RE: **LADERA BREEZE EAST (H-10/D25)**
Engineers Certification For Release of Financial Guaranty
Engineers Stamp dated 4/14/2000
Engineer's Certification dated 12/17/2001

RE: **LADERA BREEZE WEST (H-10/D25)**
Engineers Certification For Release of Financial Guaranty
Engineers Stamp dated 5/15/2000
Engineer's Certification dated 12/17/2001

Re: Ladera Breeze Drainage Report
Engineer's Stamp East dated 4-14-00
Engineer's Stamp West dated 5-15-00 (H10/D25)

Re: Ladera Breeze Drainage Report
Engineer's Stamp dated 3-24-00 (H10/D25)

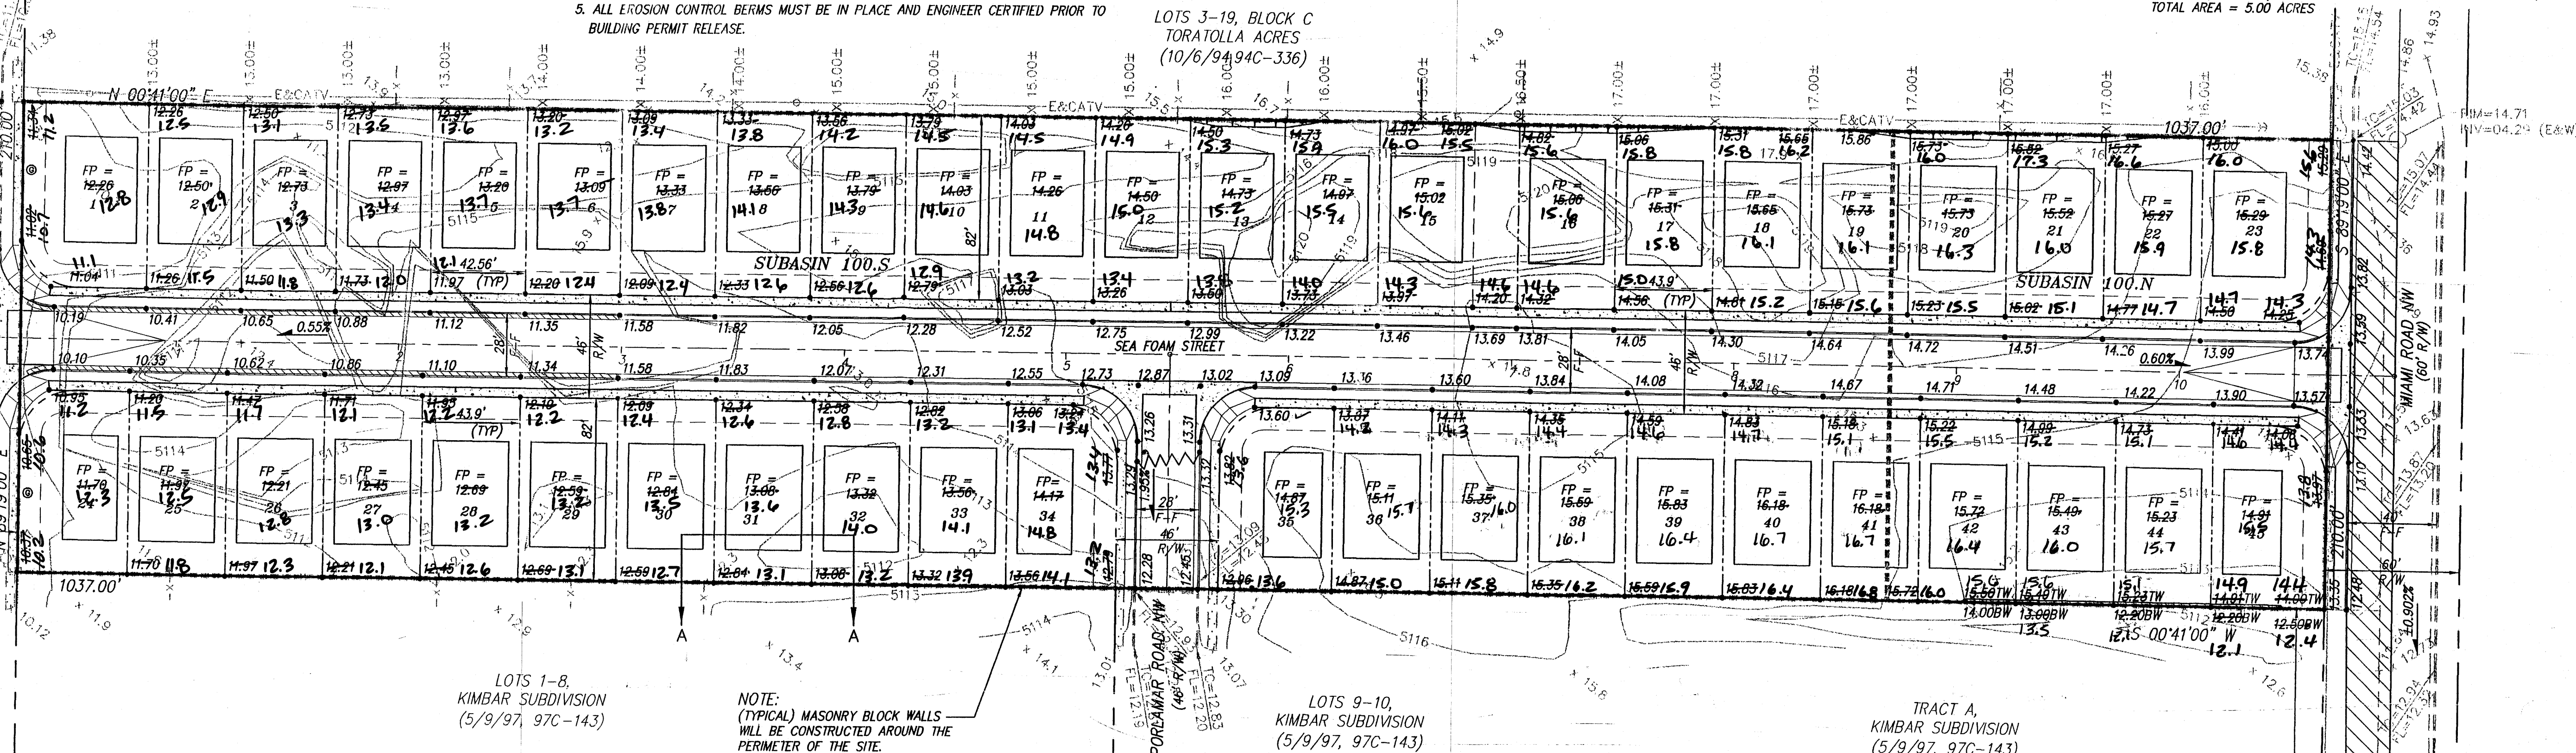
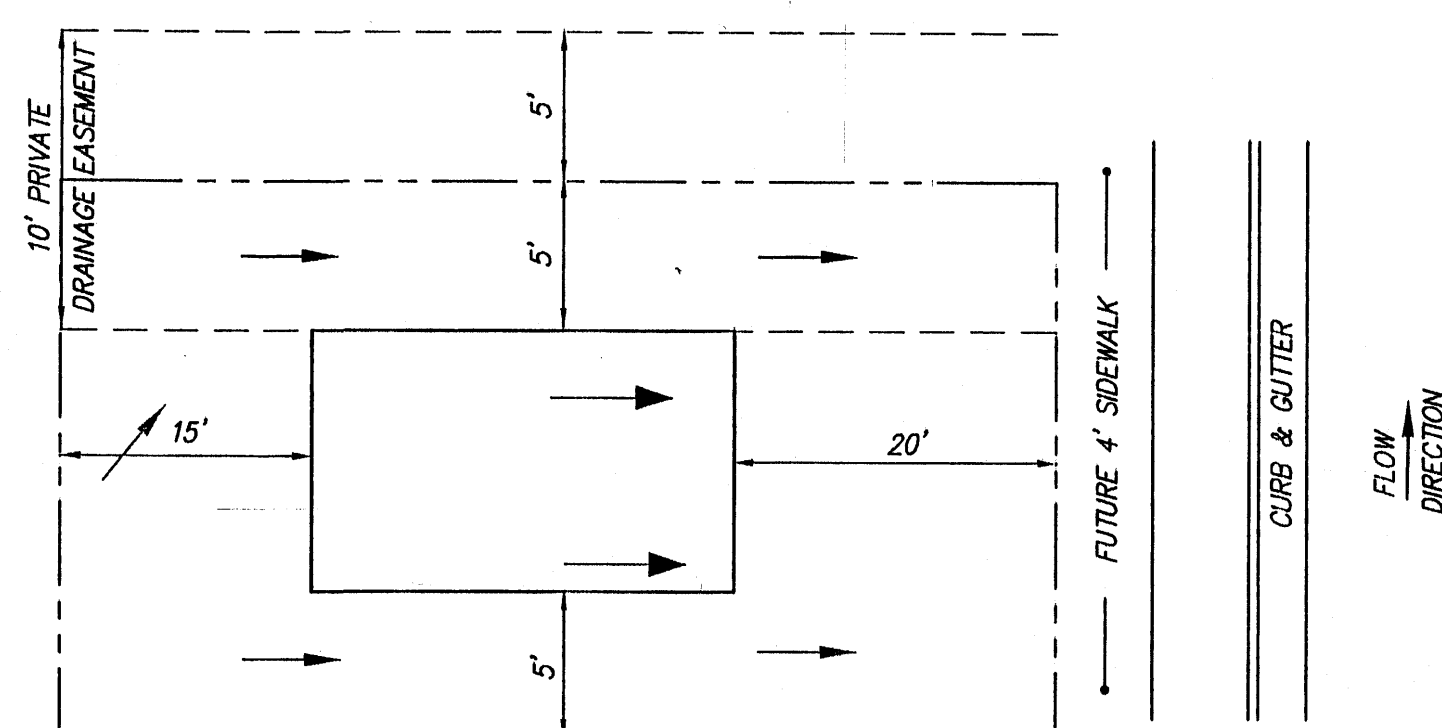
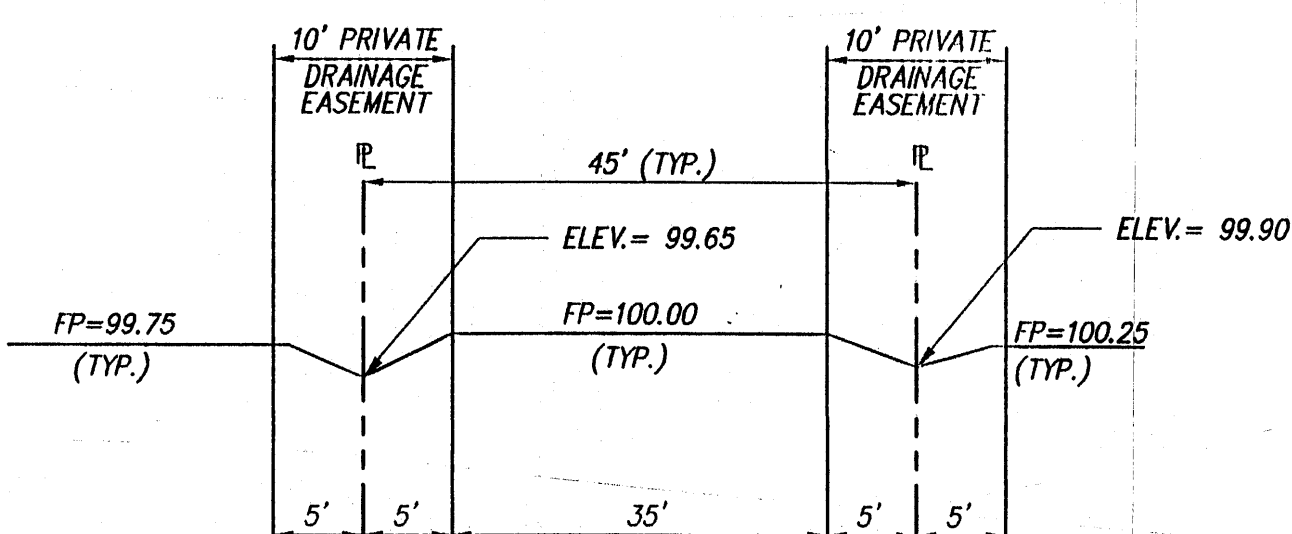
- Please indicate all areas where CMU wall is necessary for 0-1.5 feet of retaining. This will be a requirement on all future submittals as well.
- Please revise your HEC-2 section to fit in a 46-ft section, not 48-ft, and also the summary (Table 1). It should not change your data much.

1. The revised G&D plan reflects a note for the location of the CMU walls to be constructed.
2. HEC-2 runs have been revised to reflect a 46' right-of-way. These changes had no effect on the hydraulics.
3. A 5' private drainage easement is located on either side of each adjacent property line. A preliminary plat and infrastructure list are being provided with the resubmittal.
4. Yes, Miami Road is paved all the way to the inlets at 64th street. Existing tapers in Miami Road don't have extruded curb. Runoff in Miami Road between these two parcels flows to the side of the road. A field investigation revealed no signs that this insignificant amount of runoff causes a nuisance.
5. Spot elevation typo has been corrected on Lot 31. Additional spot elevations have been added to Lots 15 and 38 in Ladera Breeze East and Lots 19 and 41 in Ladera Breeze West.

CITY OF ALBUQUERQUE  
PUBLIC WORKS DEPARTMENT  
ENGINEERING DEVELOPMENT GROUP  
TITLE: **LADERA BREEZE EAST SUBDIVISION  
GRADING AND DRAINAGE PLAN**

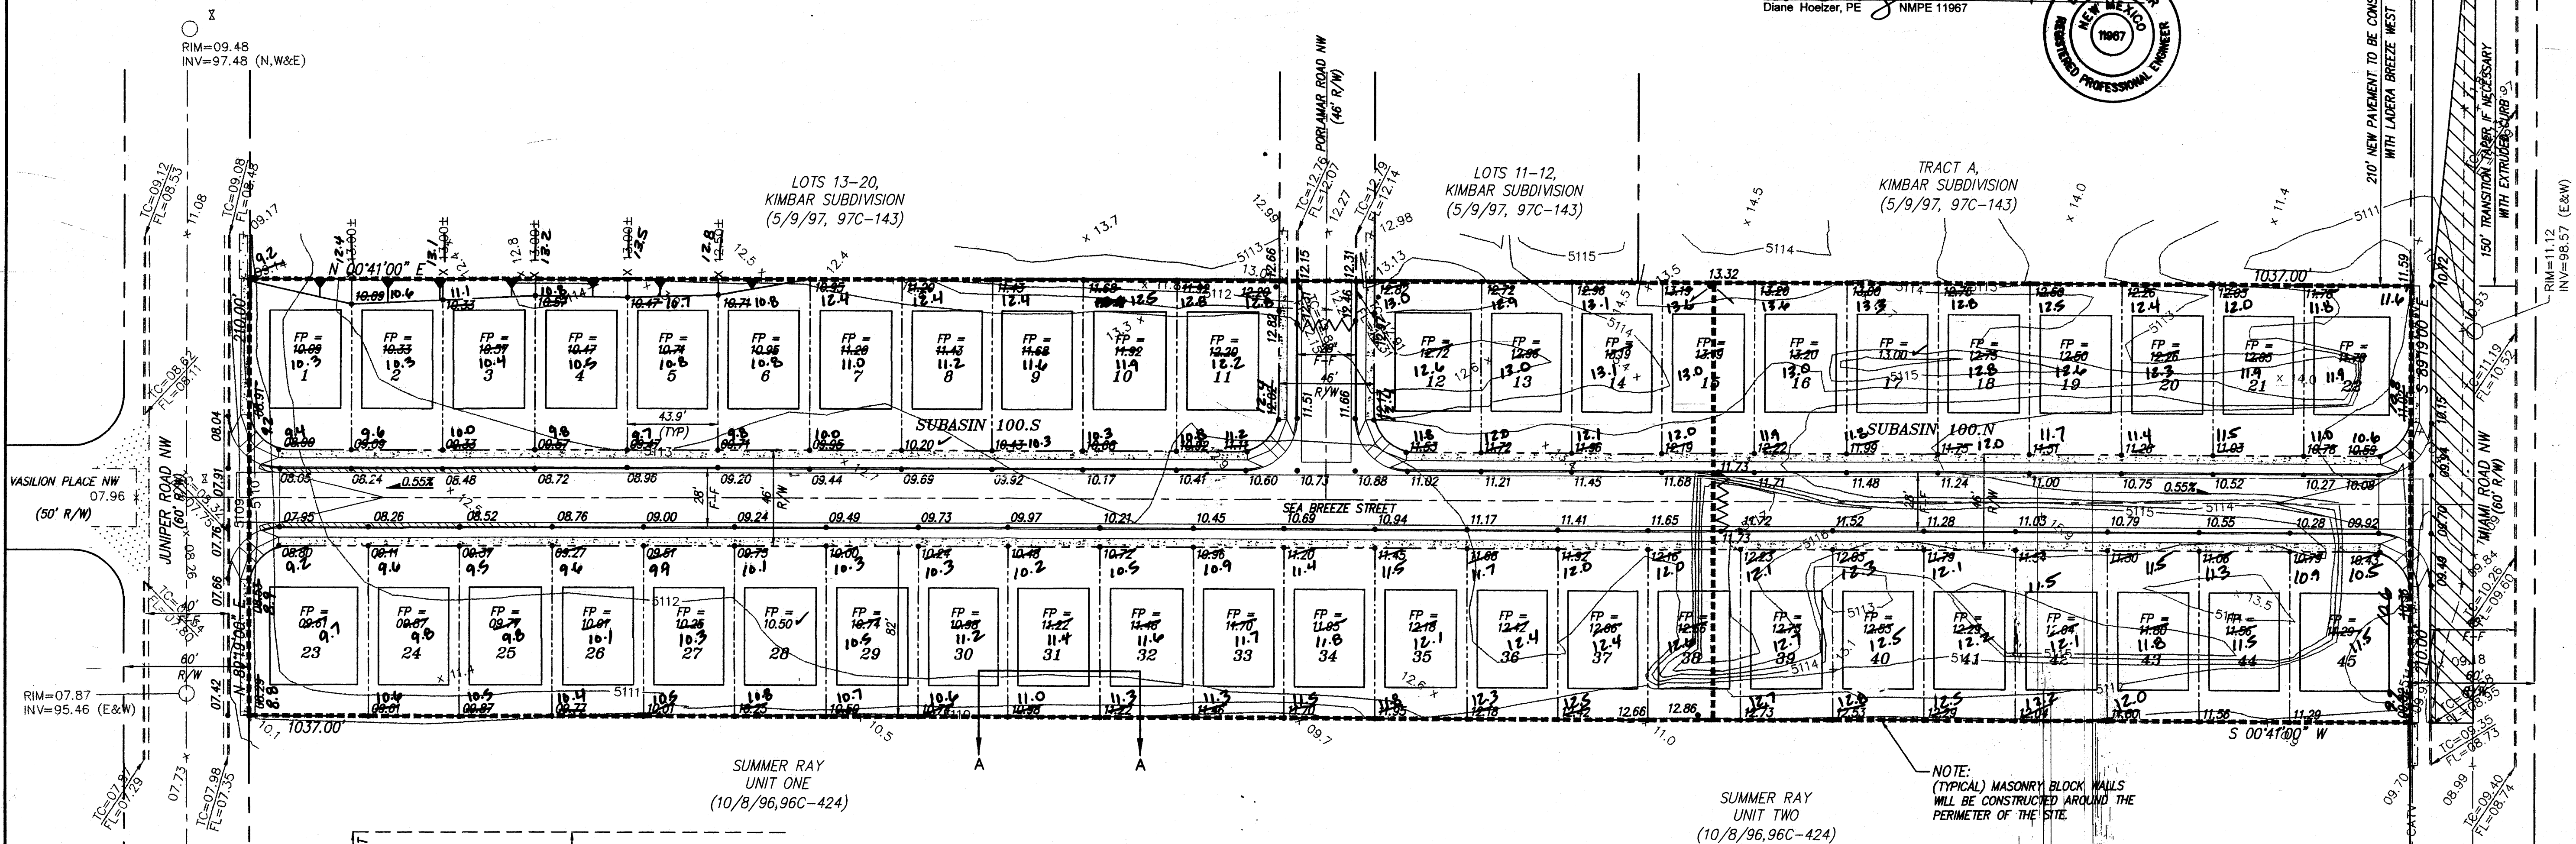
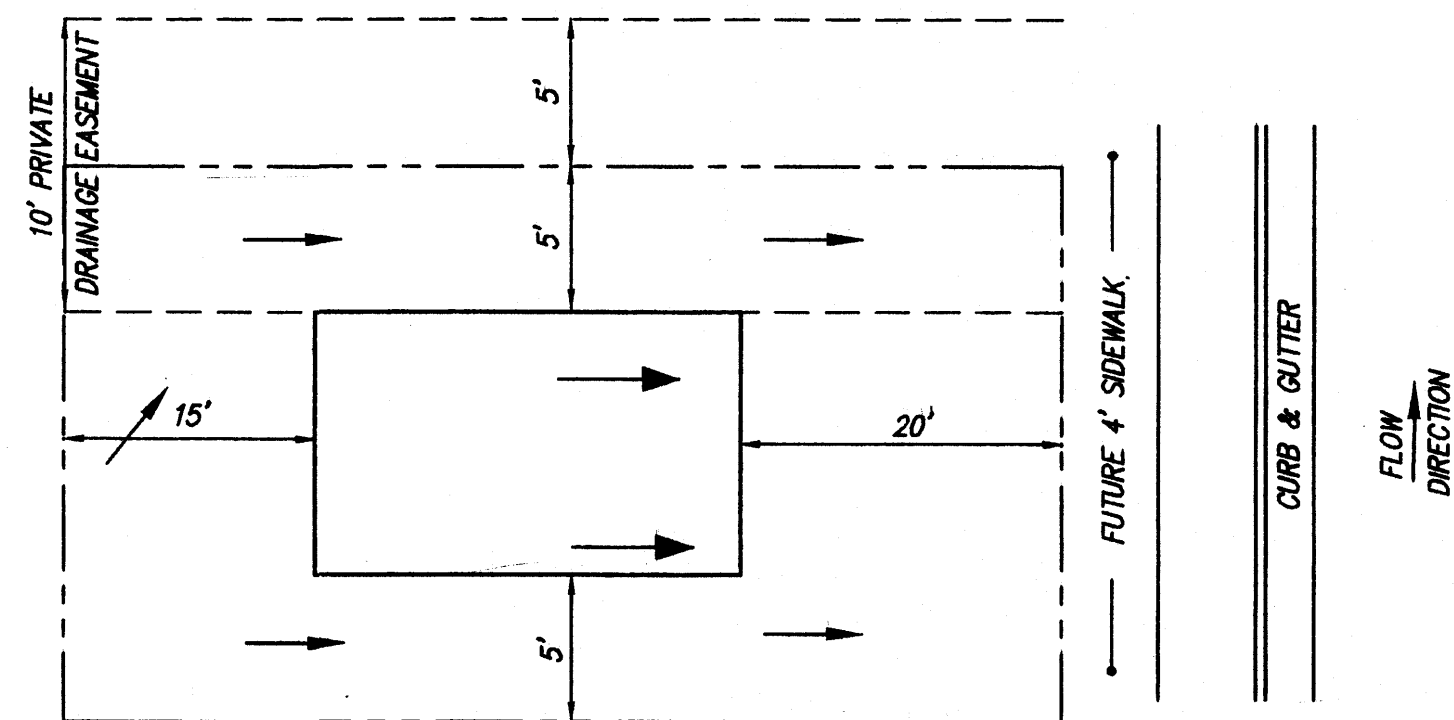
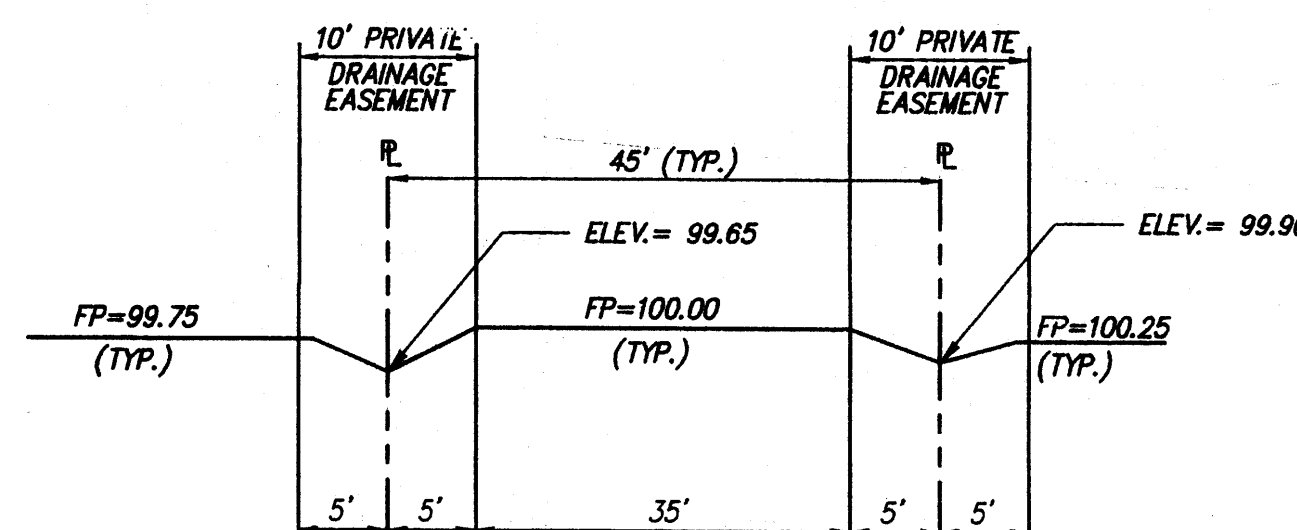
- You have a typo on the back of lot 31 East. It appears that some retaining wall will be needed along the backs of the East lots unless there is existing wall there. If so, please denote it on your plan. A spot elevation is needed on lot 15 East to establish a high point to ensure that that backyard drains.
